Review Response

Project Name: Skinner Dock & Bulkhead

Response To: SHL22-022 and SEP22-018, Request for Information #1

IMPERVIOUS SURFACE CALCULATIONS

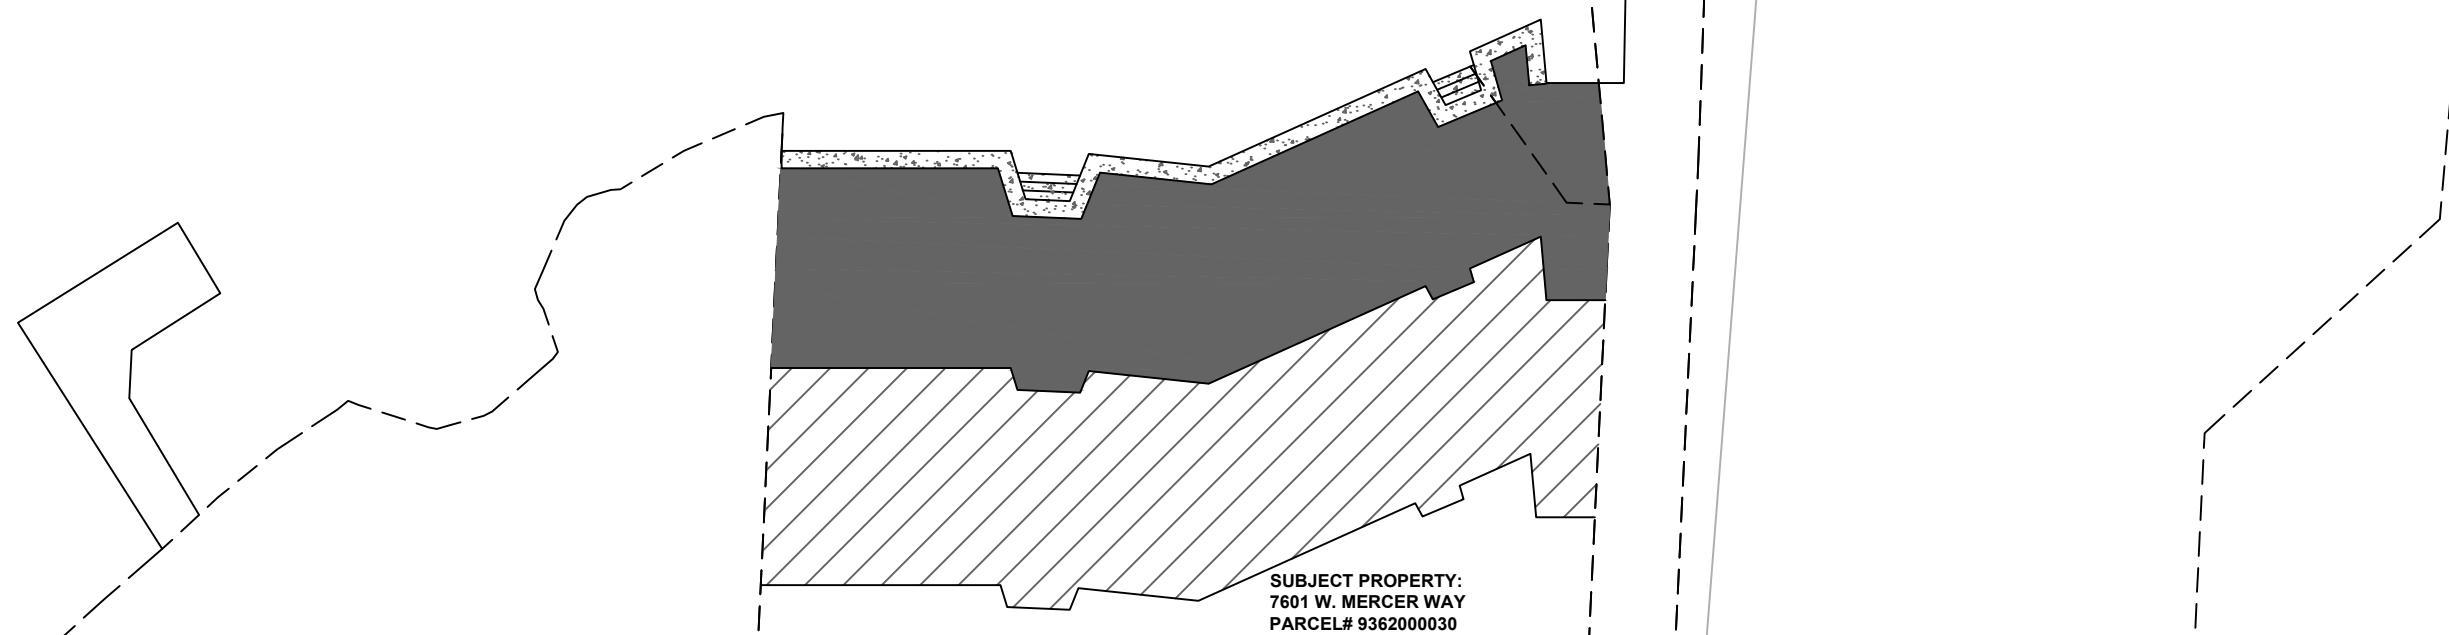
8. Please revisit the surface coverage calculations and diagrams shown on Sheet A13.0 of the plans:

- Impervious surface is not used as a coverage metric in the City of Mercer Island's shoreline master program. MICC 19.13.050(A), Table C limits hardscape and lot coverage to:
 - o 10% of the area between 0 and 25 feet landward of the OHWM, and
 - o 30% of the area between 25 and 50 feet landward of the OHWM

Please correct the calculations and diagram to measure hardscape and lot coverage instead of impervious surface.

- Aerial imagery shows that the existing house is within 50 feet of the OHWM. Please show the house, as well as any other hardscape or lot coverage within 50 feet of the OHWM, on the coverage diagram and account for it in the calculations showing compliance with the hardscape and lot coverage requirements listed in MICC 19.13.050(A), Table C.

Understood – see A13 of update plan set.

Understood – see A13 of update plan set.
